2. **Project # 1004769**
13DRB-70678 MINOR-PRELIMINARY/
FINAL PLAT APPROVAL

**CITY OF ALBUQUERQUE
PLANNING DEPARTMENT
September 25, 2013
DRB Comments**

PROJECT # 1004769

RE: Lots 25 & 26A, Block 109, Snow Heights Addition

MENAU BOULEVARD N.E.
 (97' R.O.W.)

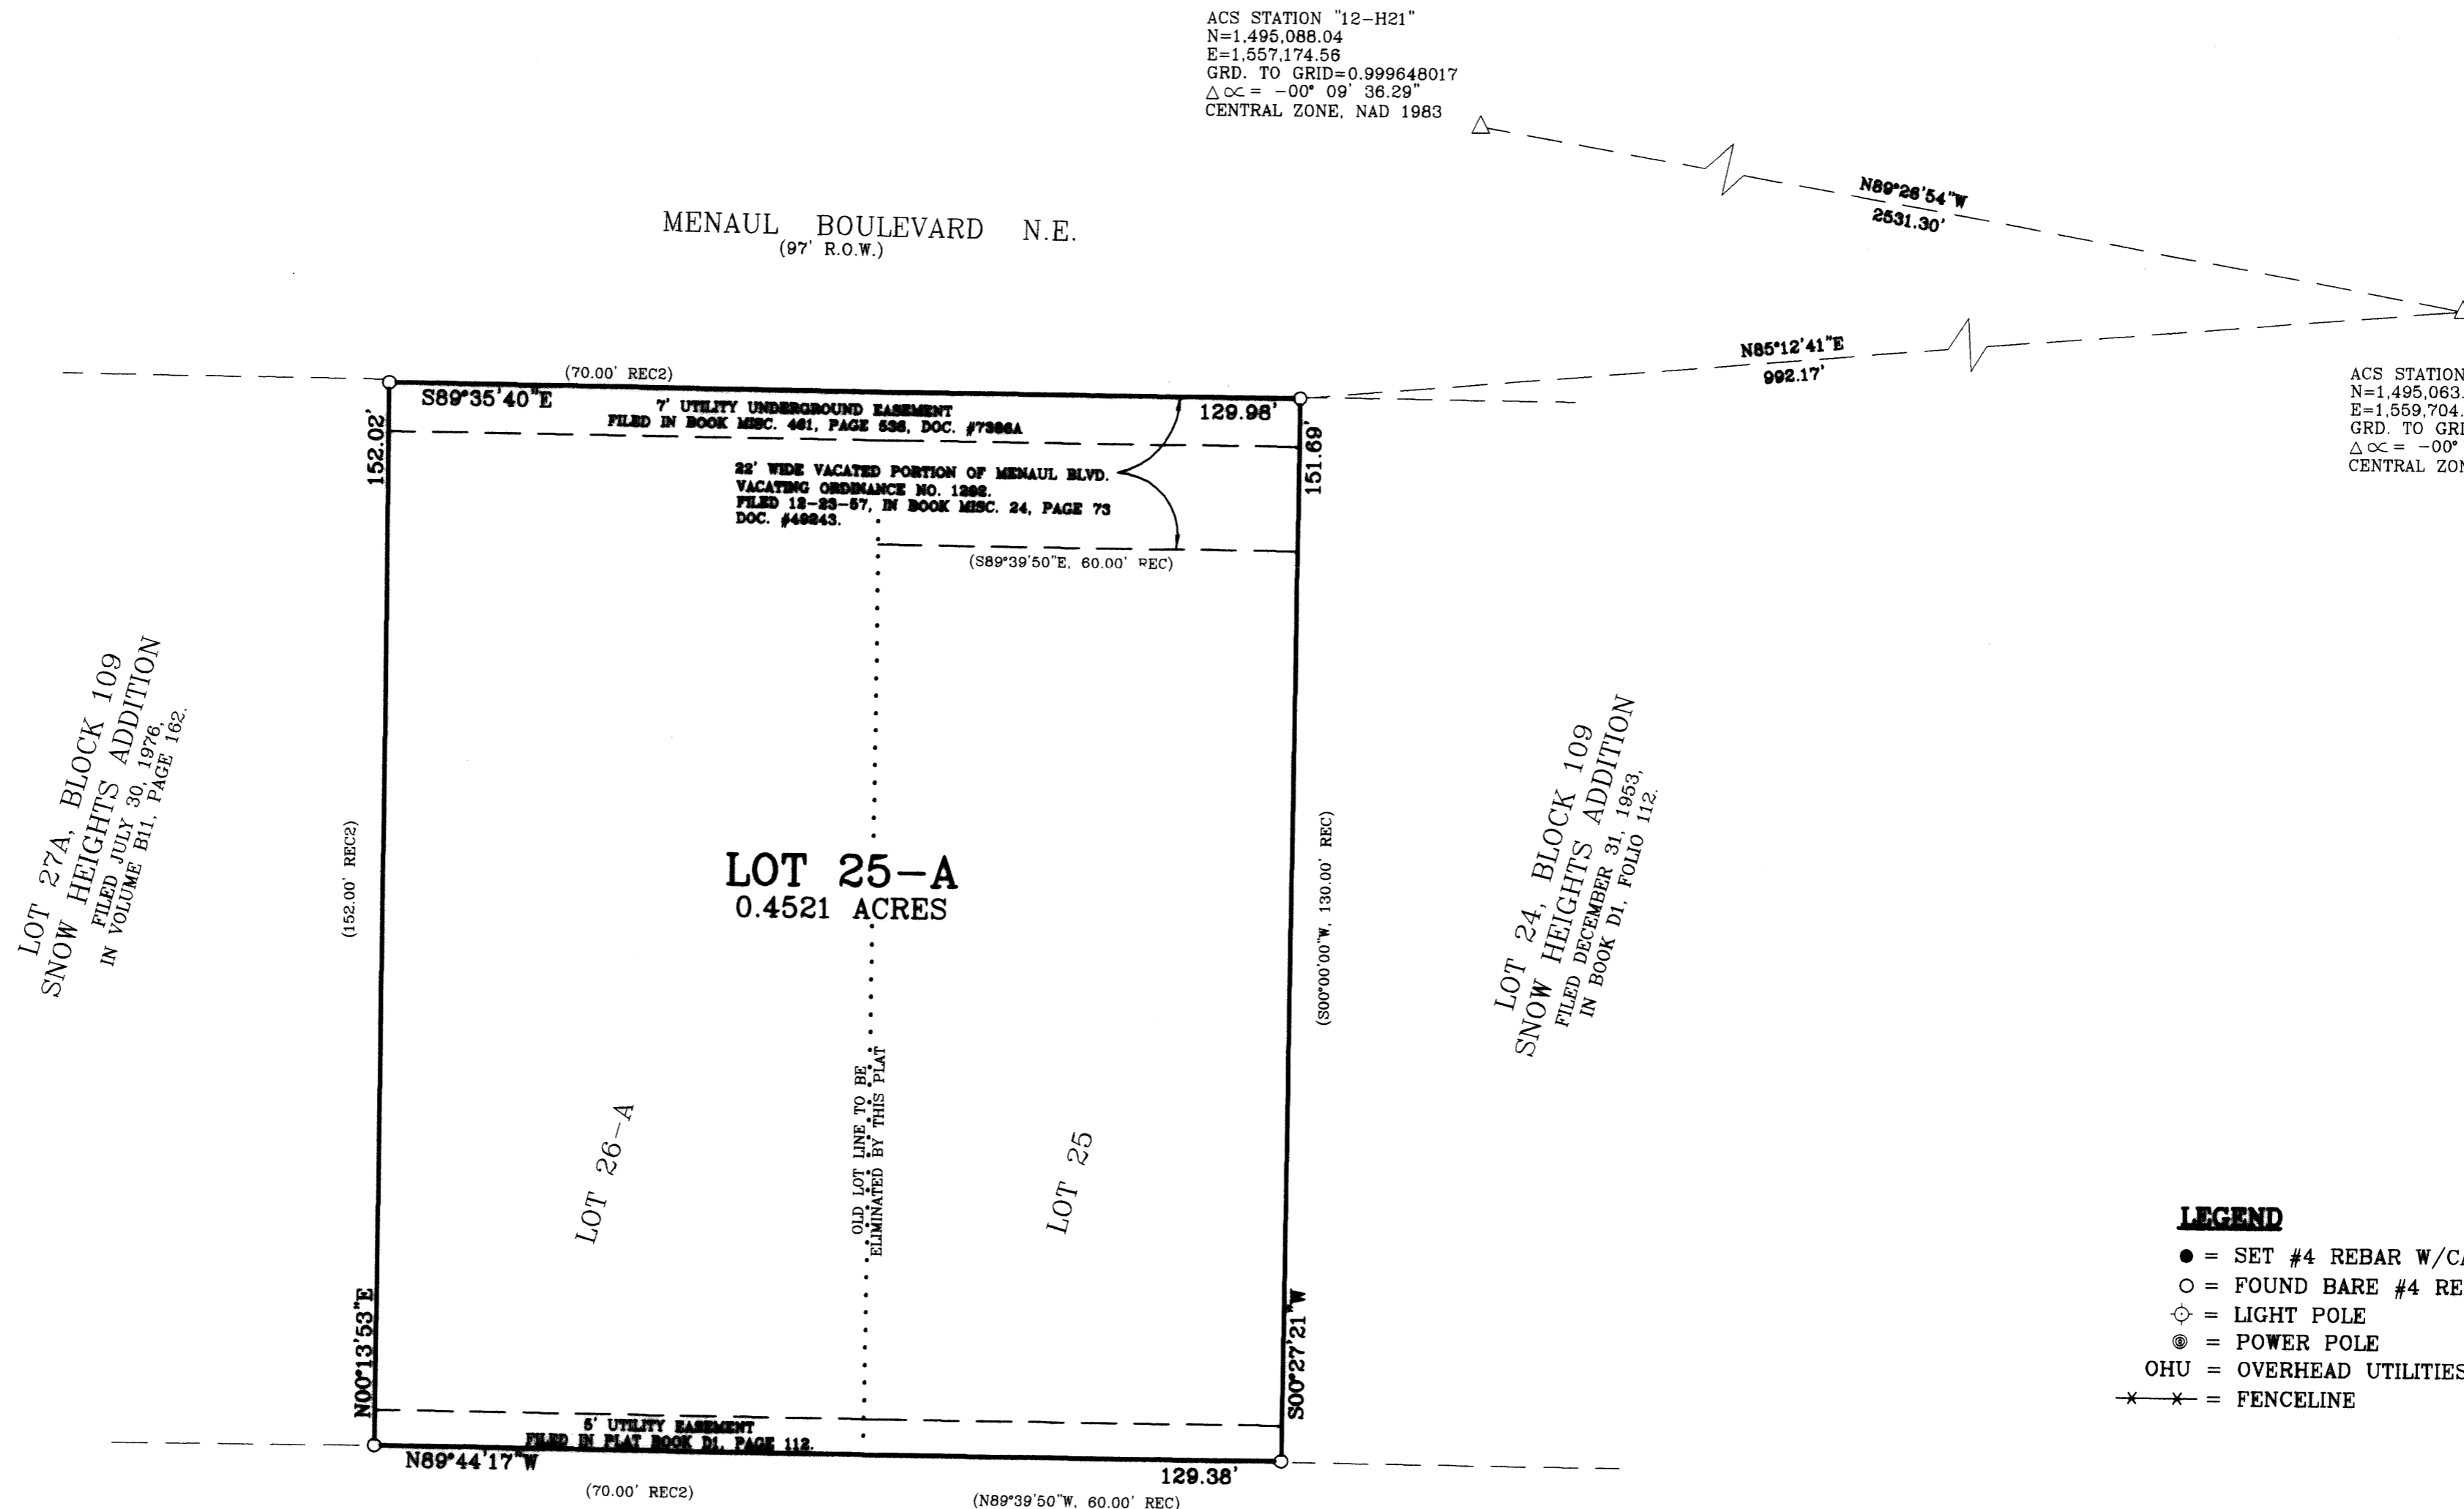
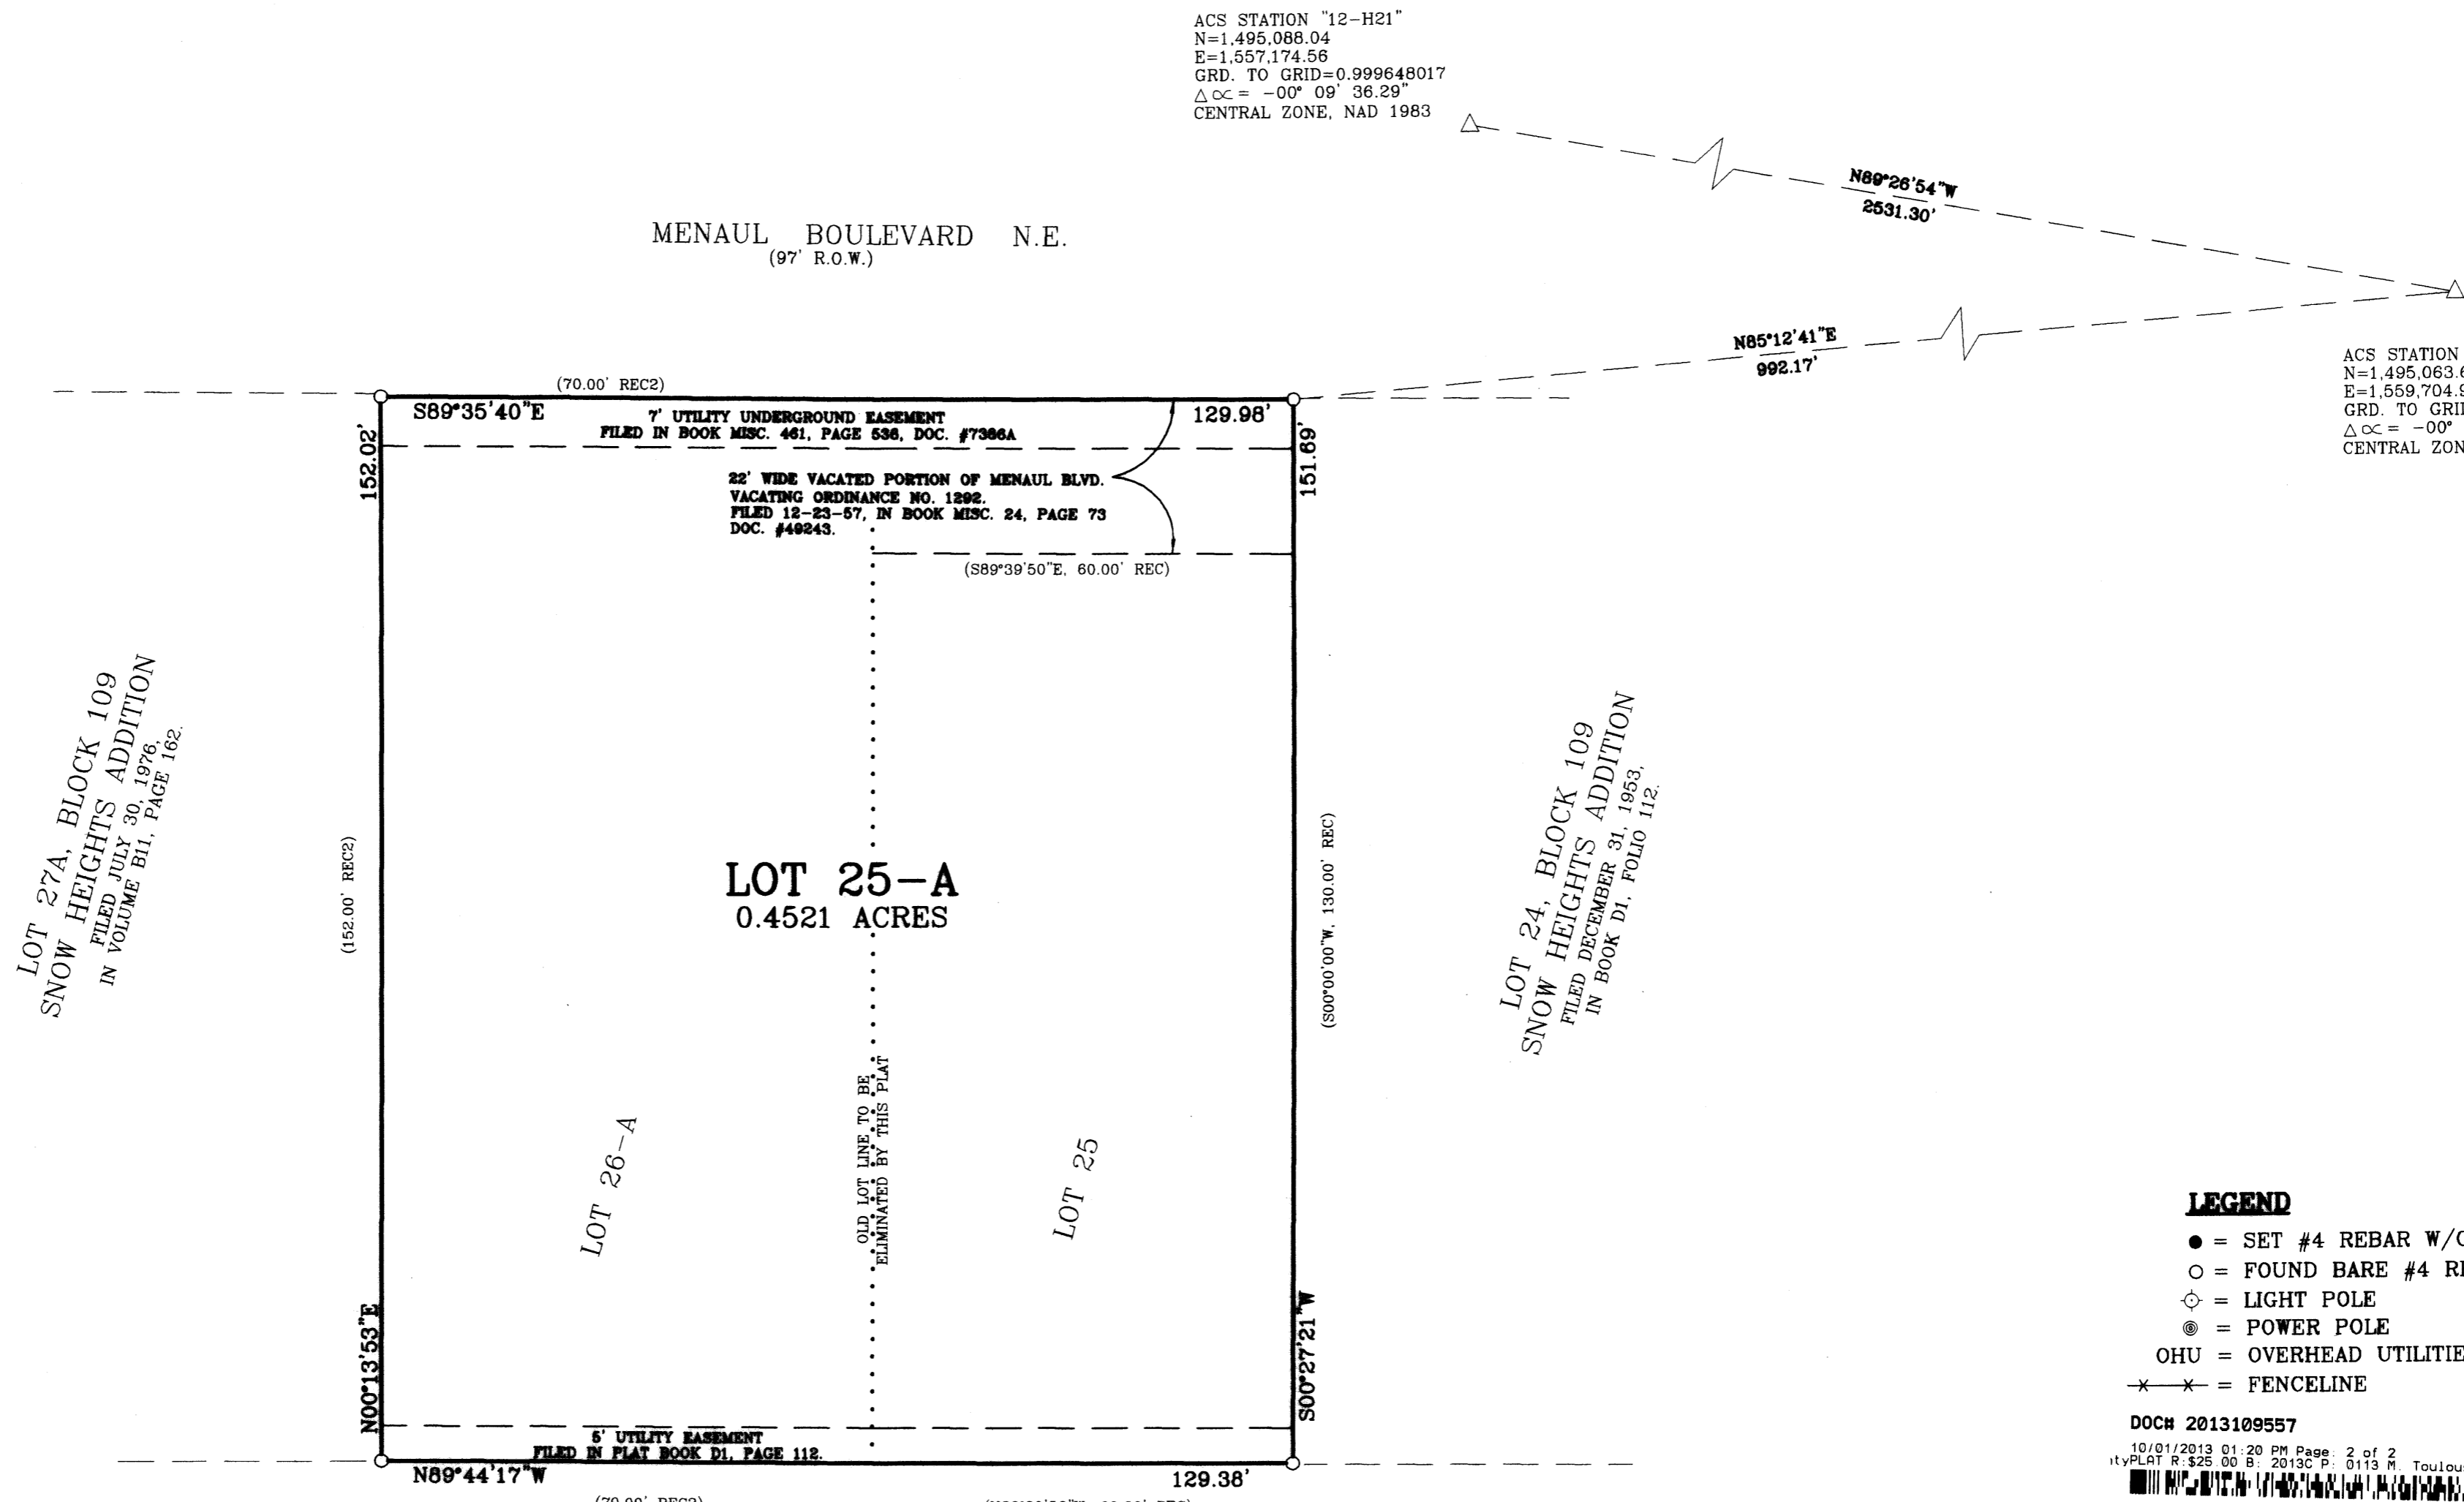
A copy of the Vacation Ordinance 1292 [12-23-57] needs to be provided for the file, and Property Management needs to sign off on the plat for final approval.
